Fountain Tracking Number # SP-26-006

Kroger Spoke – Site Development Plan | 702 Bandley Drive, Fountain, CO 80817

Please see below for responses to the plan review comments provided by your department. We have provided an itemized list of the comments with responses below it. Please refer to the attached drawings with revision clouds in response to the comments.

C-406

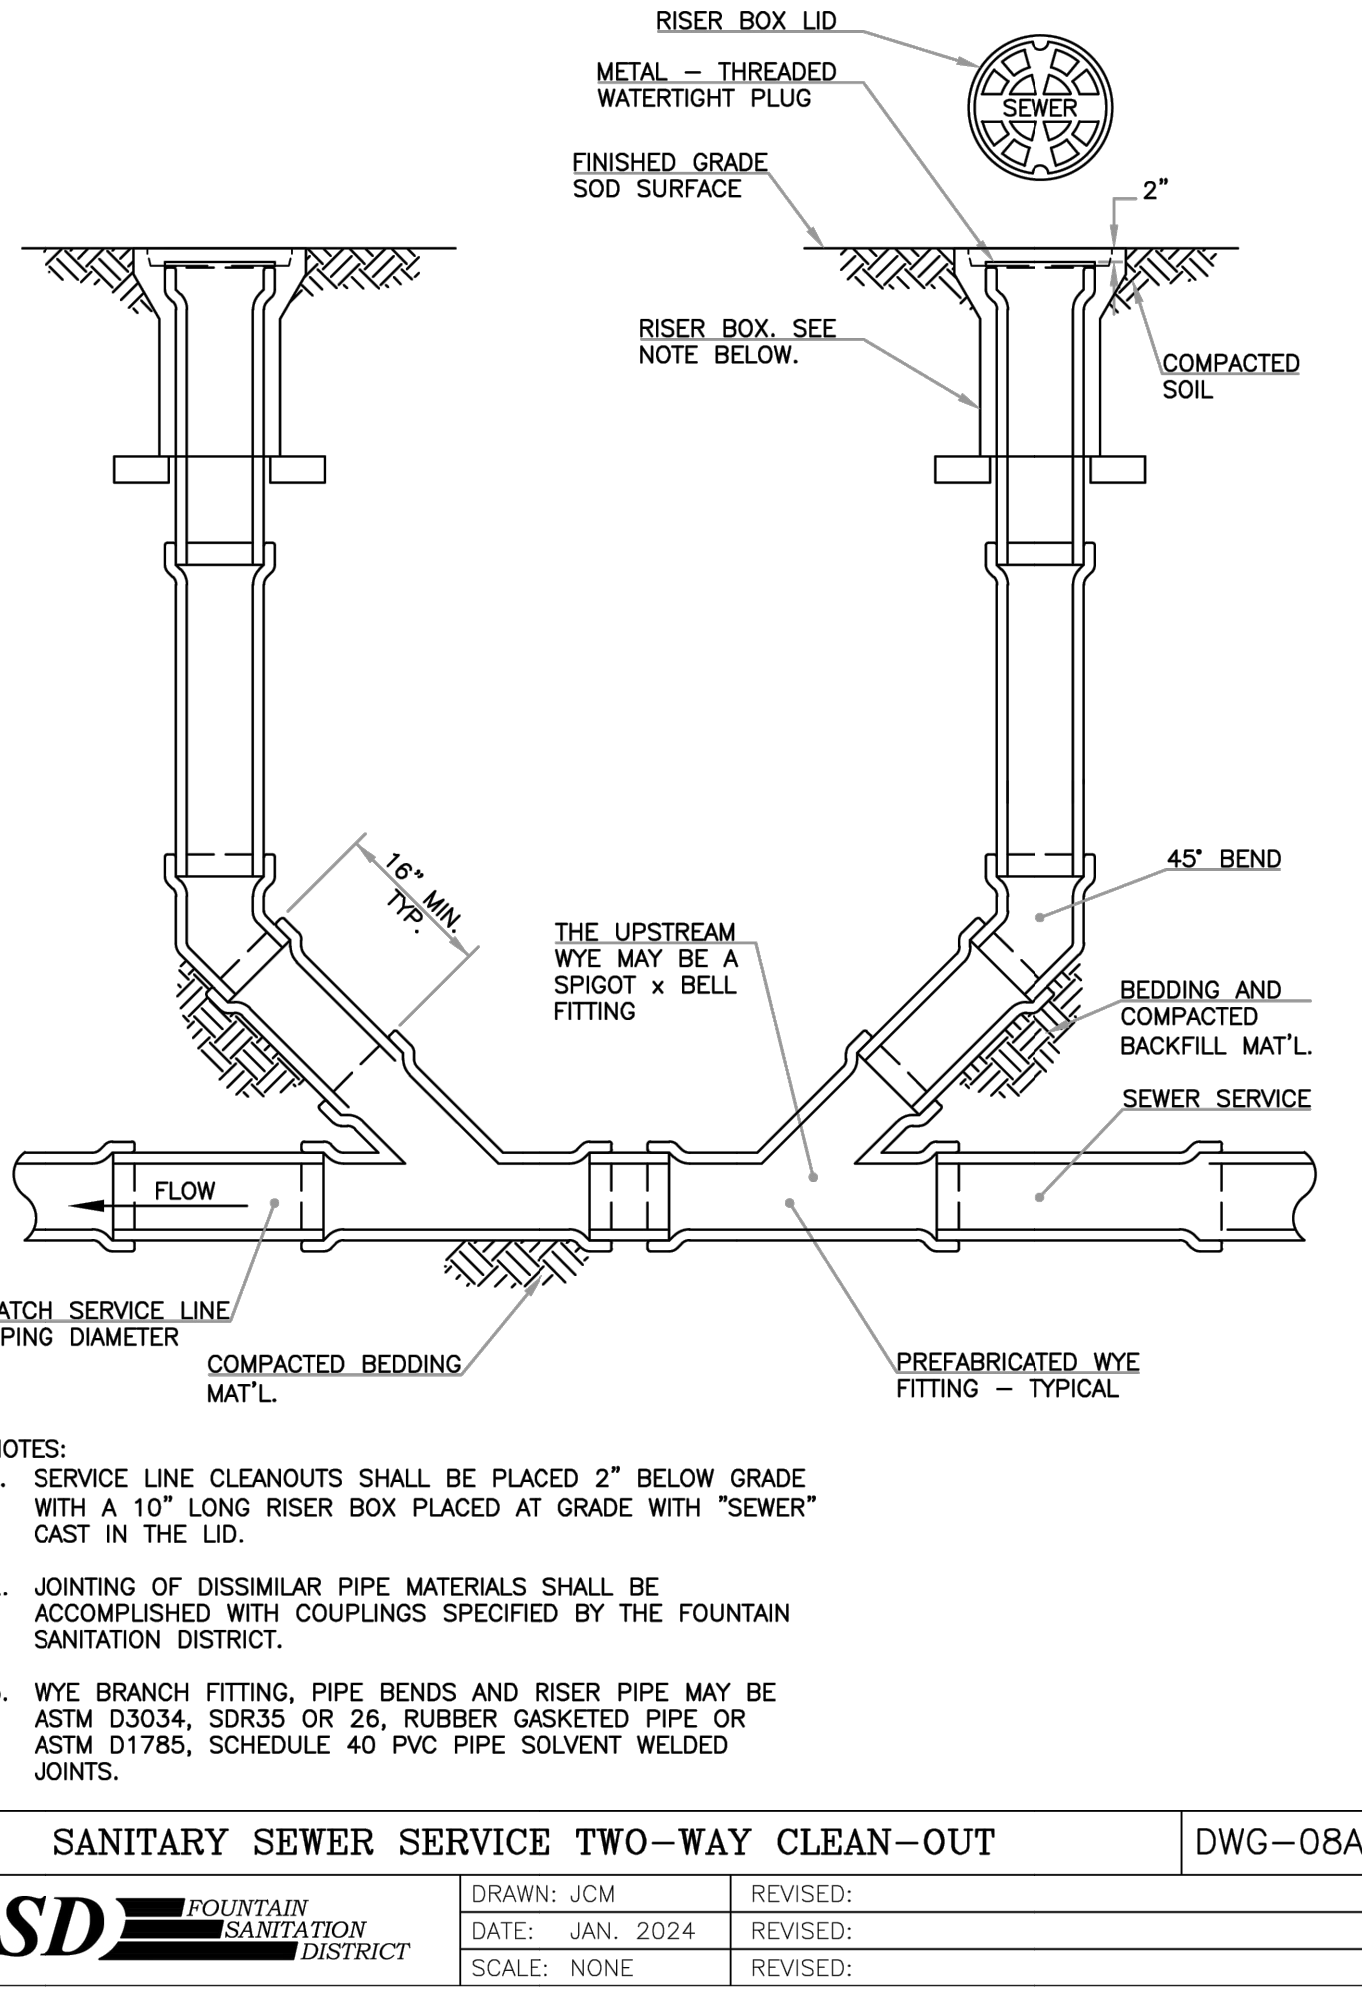
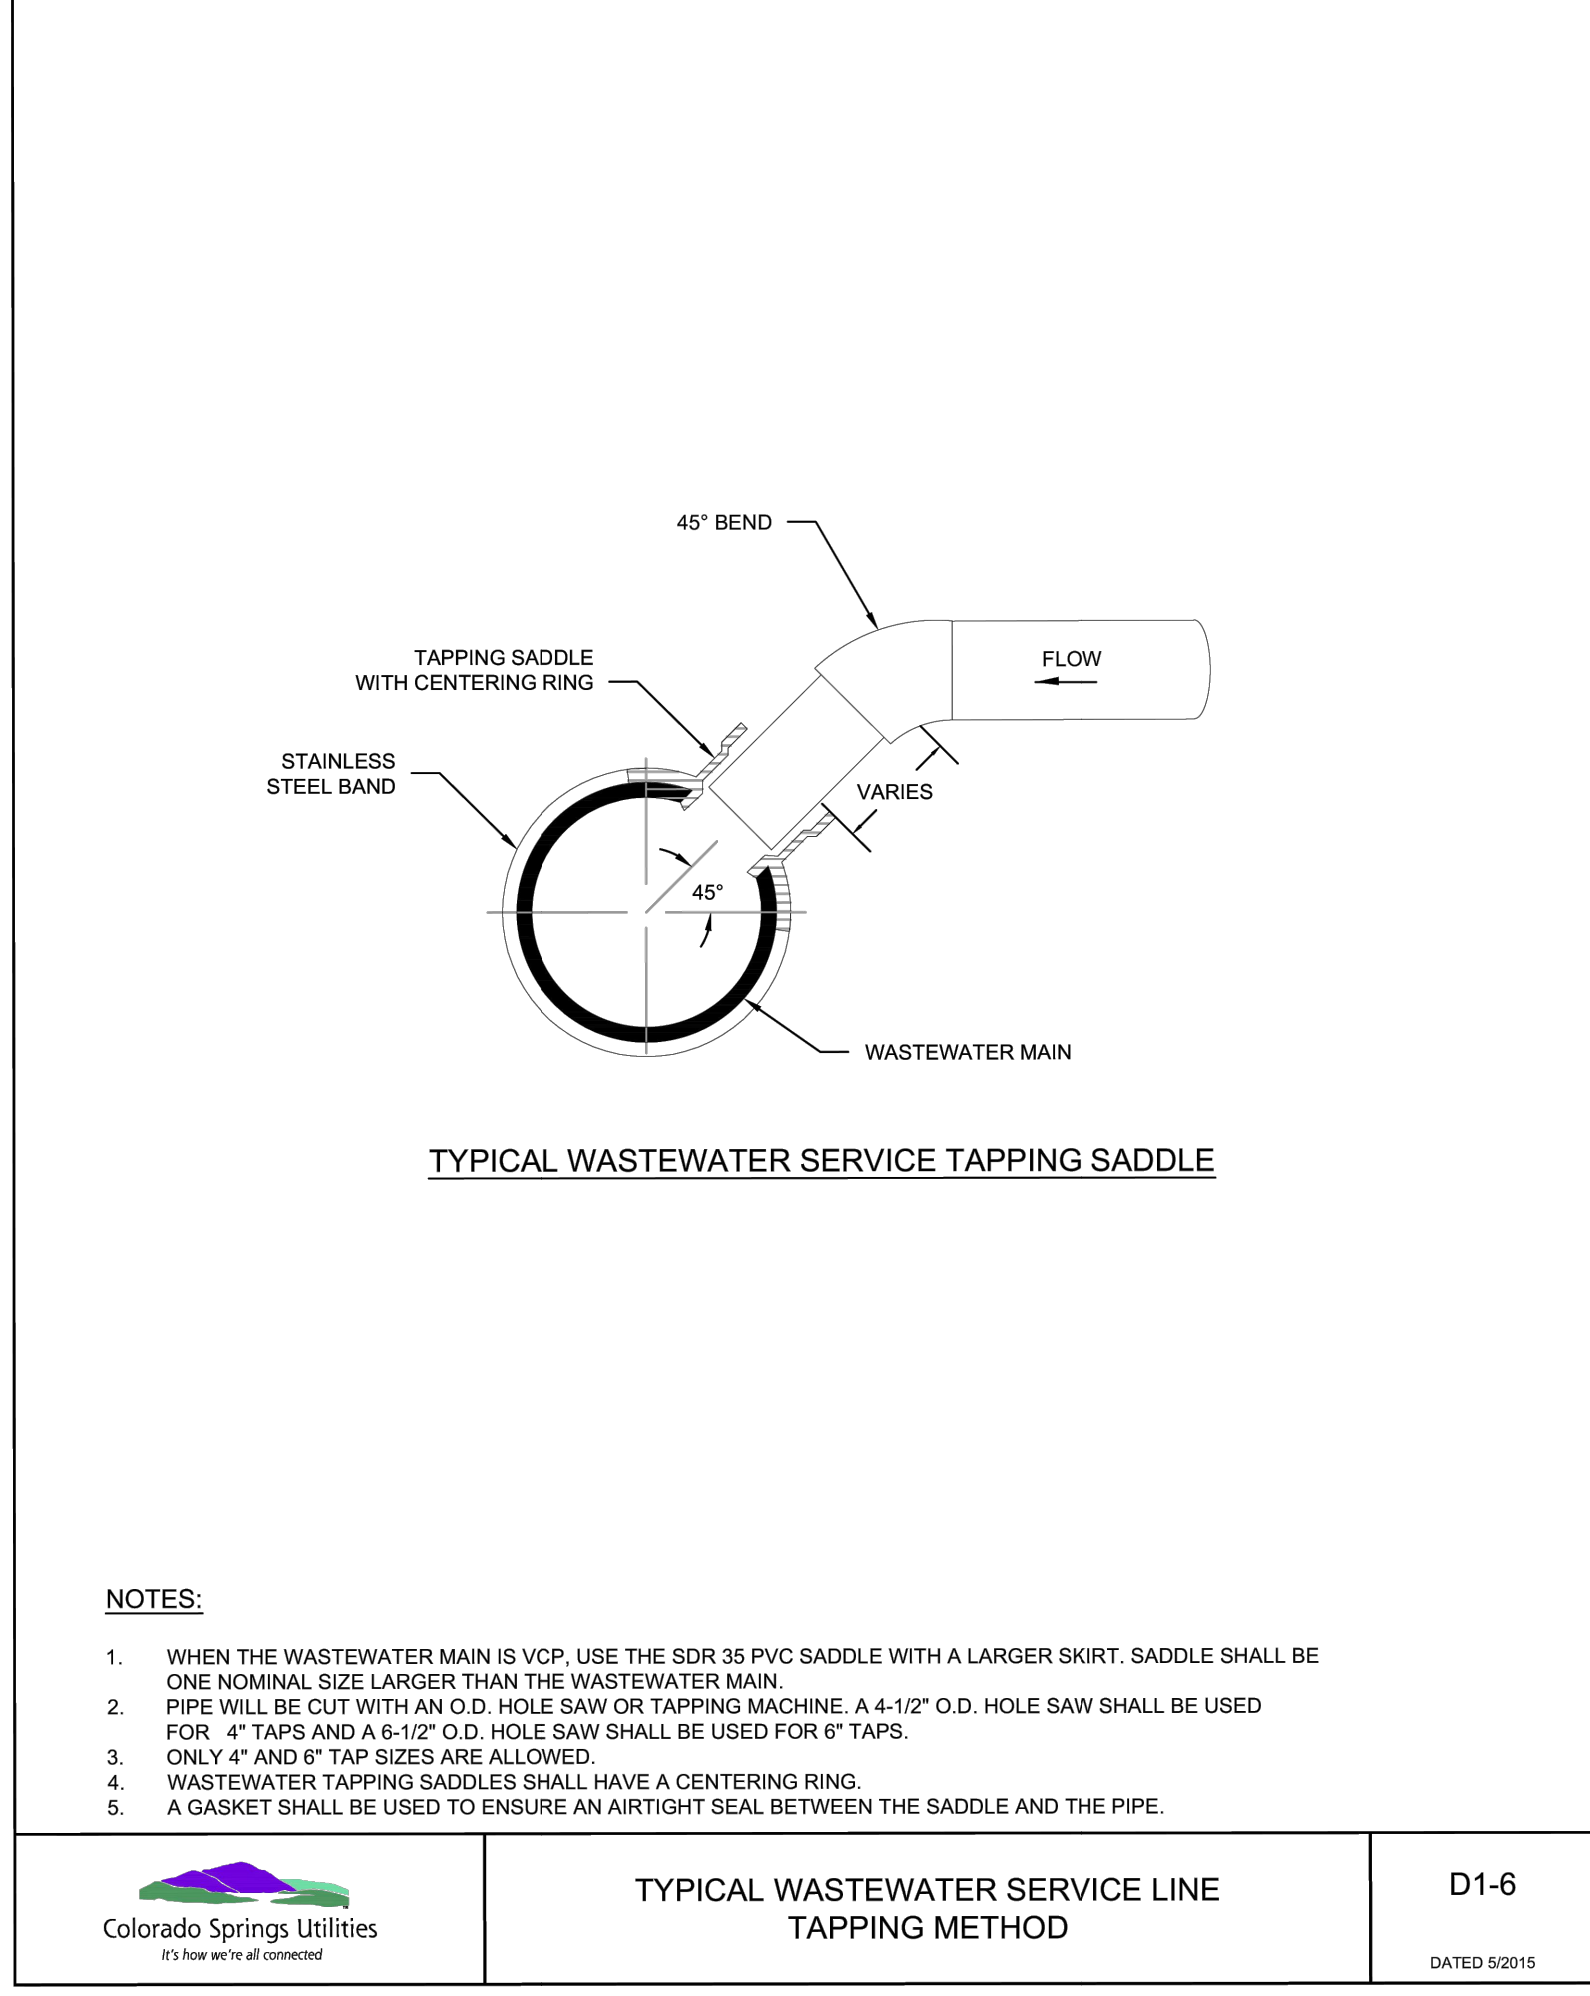
1. C-406 Construction Details - remove details

2. C-406 Construction Details - remove and replace with detail DWG-03

3. C-406 Construction Details - Add FSD detail DWG-08A

4. C-406 Construction Details - Add detail from Colorado Springs Utilities D1-6

5. C-406 Construction Details - remove detail

Response: Details Removed.

Response: Detail Added. Reference C-406.

Response: Detail Added. Reference C-406.

Response: Detail Added. Reference C-406.

Response: Details Removed.
